SUBJECT: Nash County; Replacement of Bridge Nos. 85, 141, 151, and Culvert
C70 over Swift Creek and Culvert C161 over Lane Swamp on US 301;
Federal Aid Project No. BRSTP-0301(25); WBS 42270.1.1;
TIP B-5124.

Action ID No. SAW-2014-01802

This office received permit modifications dated April 9, 2015, affecting areas of the above referenced project. The modification request is detailed as follows:

PROJECT REFERENCE NO. B-5124	SHEET NO. 4
RW SHEET NO.	
ROADWAY DESIGN ENGINEER	HYDRAULICS ENGINEER
PRELIMINARY PLANS DO NOT USE FOR CONSTRUCTION

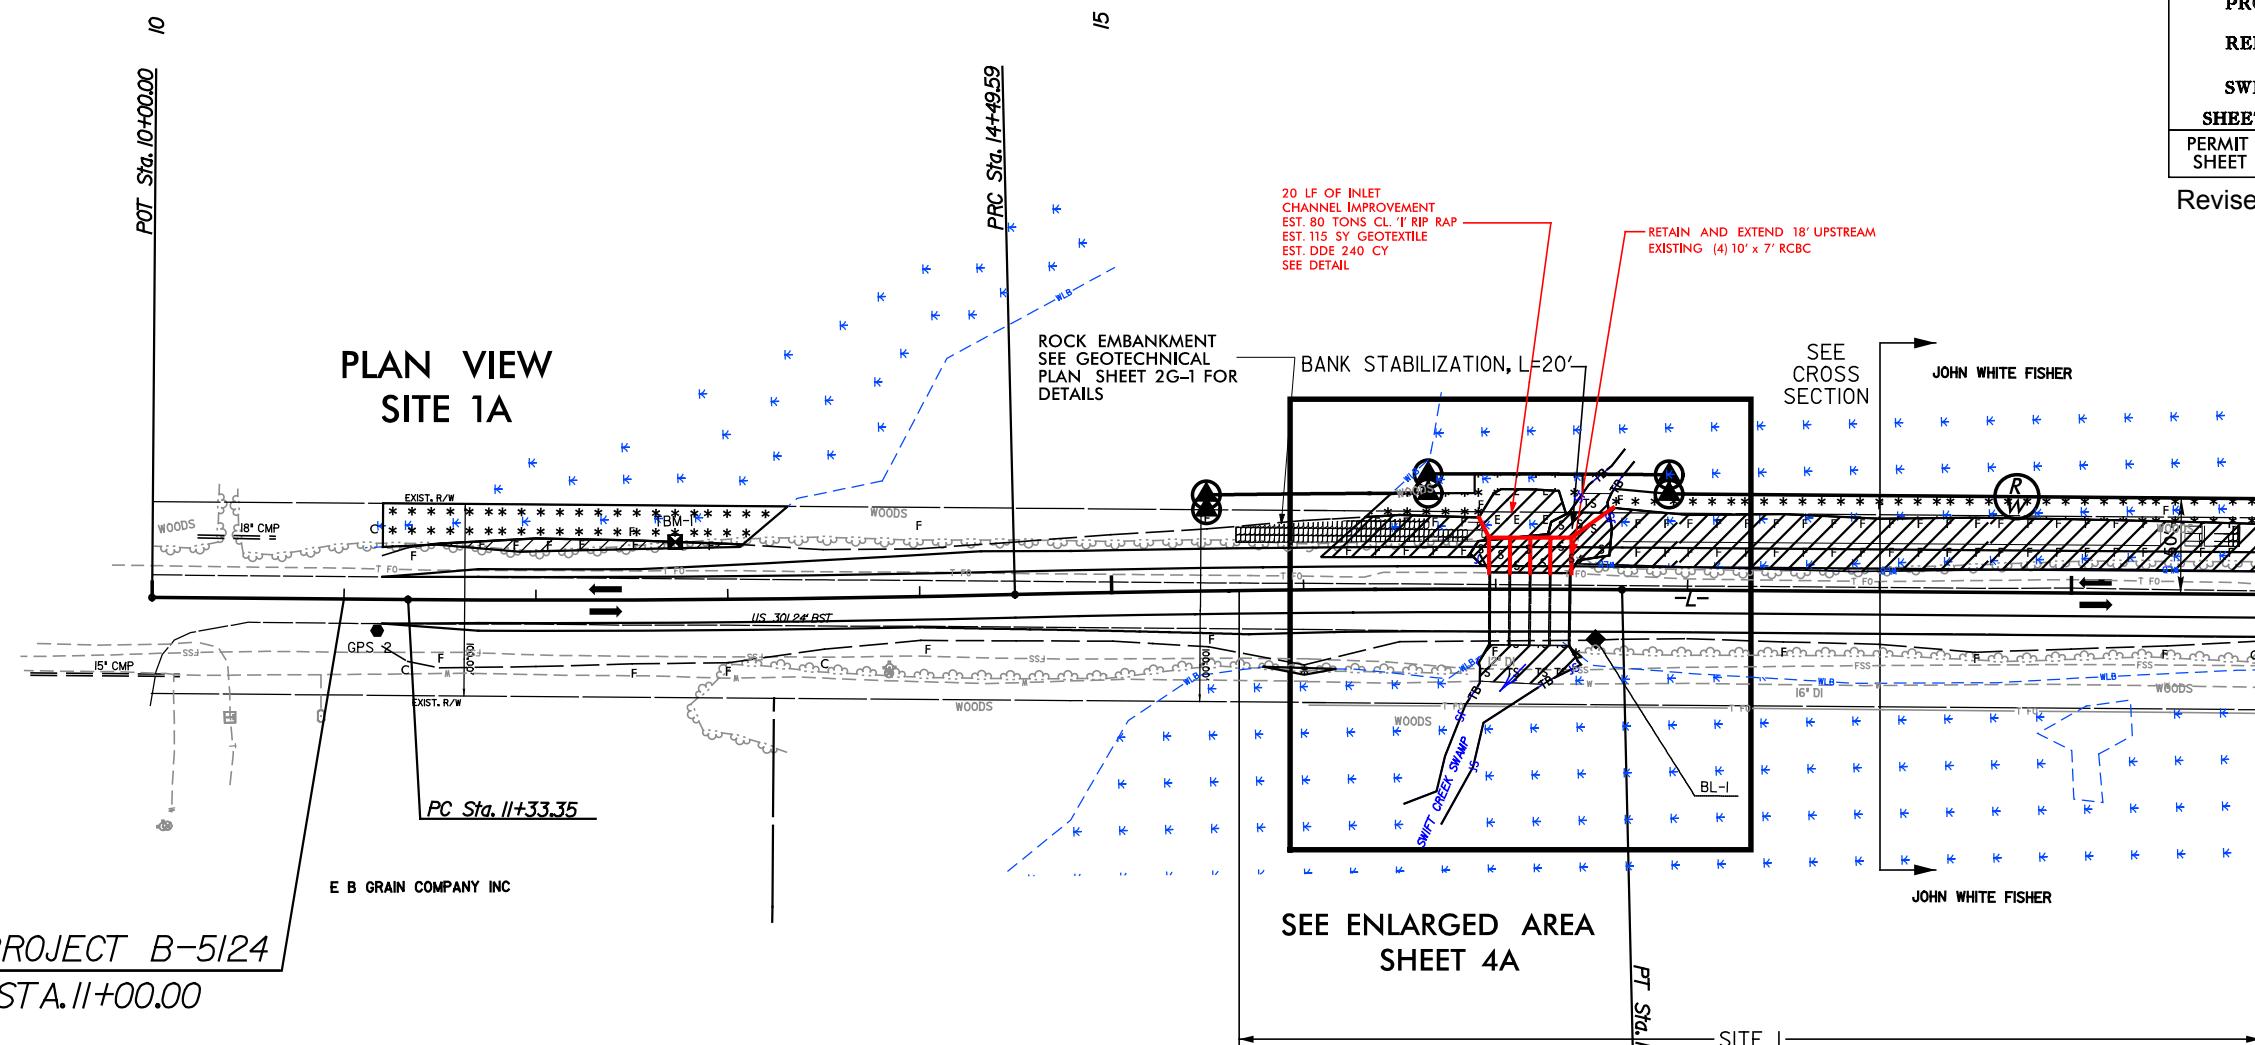
1). The southern portion of the project area has been extended to accommodate a roadway transition between existing and new location construction. Mechanized clearing impacts to riparian wetlands will increase by 0.09 acre to a total of 1.84 acres and permanent fill to riparian wetlands will increase by 0.02 acre to 2.38 acres.

This modification request was discussed and coordinated with the appropriate State and Federal agencies and the coordination revealed no objections to this modification request. The proposed modifications for B-5124 as detailed above are hereby modified in accordance with the specific work activities described and depicted on the plan sheets, drawings and descriptions enclosed with the permit modification request package dated April 9, 2015. A revised wetland permit impact summary sheet is attached and noted as Permit Drawing Sheet 2 and 4 of 51 and dated April 7, 2015.
